**United Utilities Water Limited  
Developer Services & Planning**  
Warrington North WWTW  
Barnard Street off Old Liverpool Road  
Gatewarth Industrial Estate  
Sankey Bridges  
Warrington  
WA5 1DS

**Your ref:** 3/2016/0146  
**Our ref:** DC/16/775  
**Date:** 14-MAR-16

**Location: Old Row, Whalley Rd, Barrow**  
**Proposal: residential development of 23 dwellings**

drawing: **PROPOSED SITE LAYOUT**

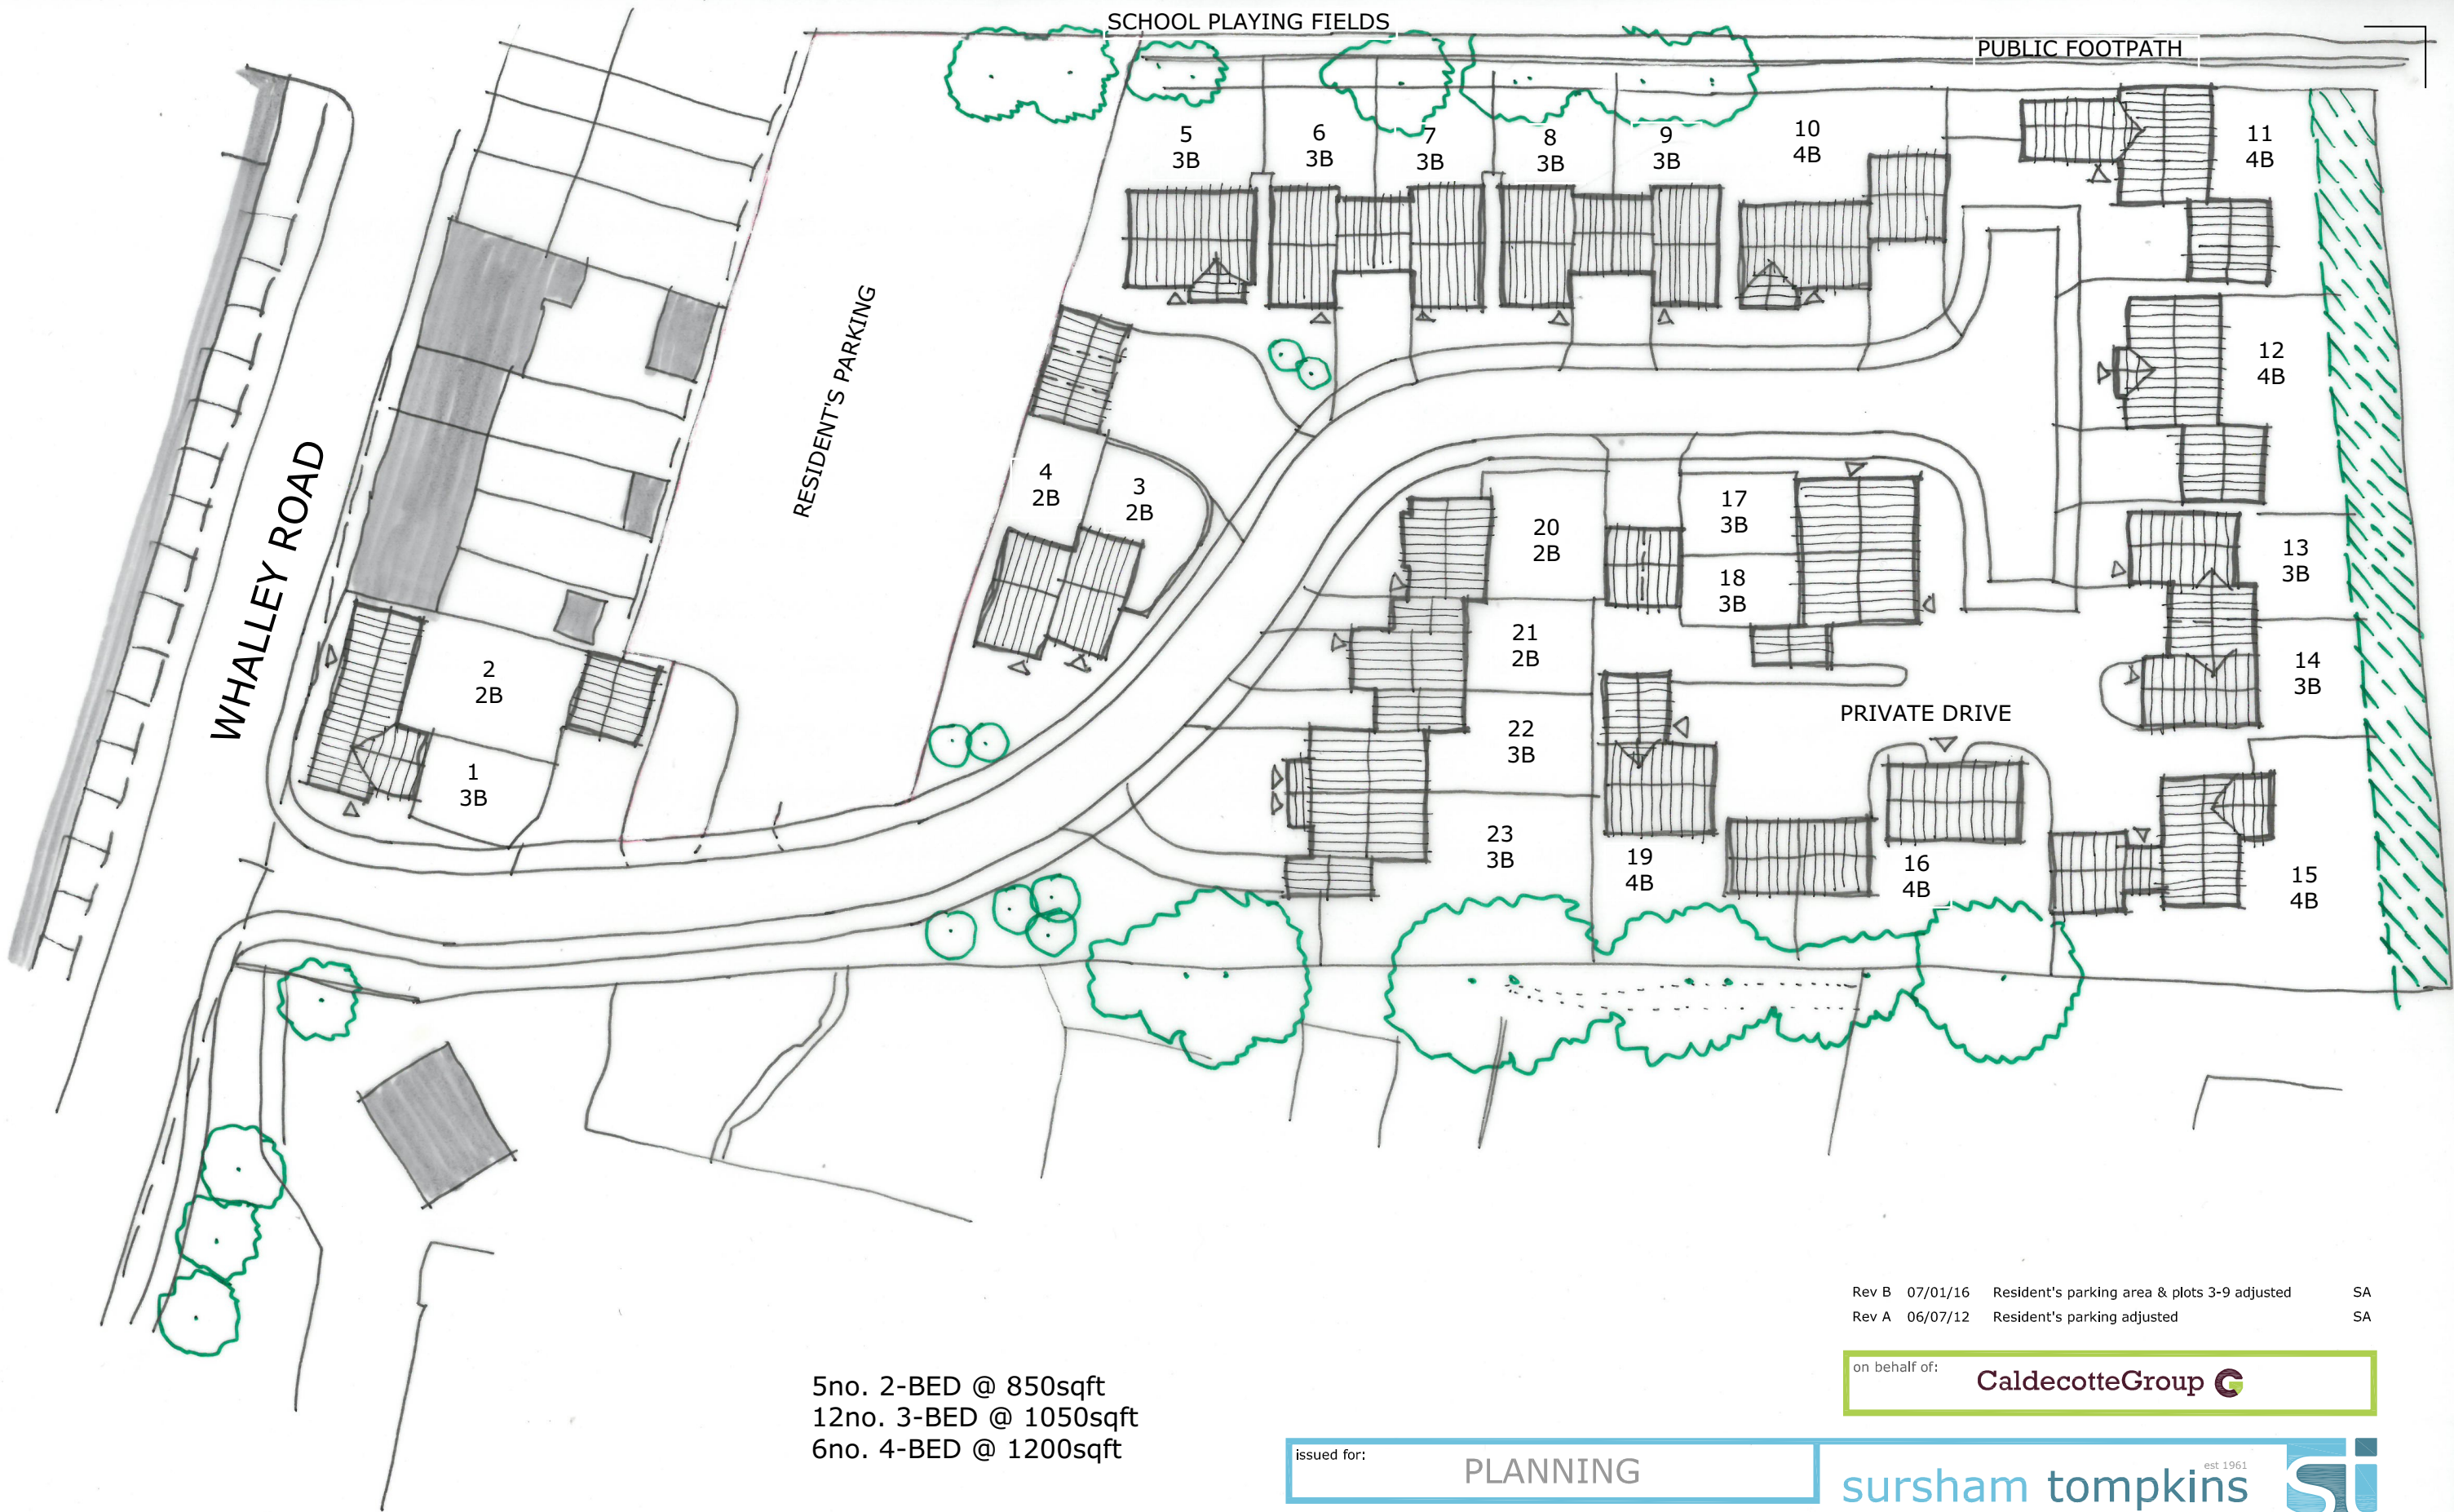
A water main crosses the site. As we need access for operating and maintaining it, we will not permit development in close proximity to the main. You will need an access strip of no less than 5 metres, measuring at least 2.5 metres either side of the centre line of the pipe. The applicant must comply with our standard conditions, a copy of which is enclosed, for work carried out on, or when crossing aqueducts and easements. This should be taken into account in the final site layout, or a diversion will be necessary, which will be at the applicant's expense. Any necessary disconnection or diversion required as a result of any development will be carried out at the developer's expense. Under the Water Industry Act 1991, Sections 158 & 159, we have the right to inspect, maintain, adjust, repair or
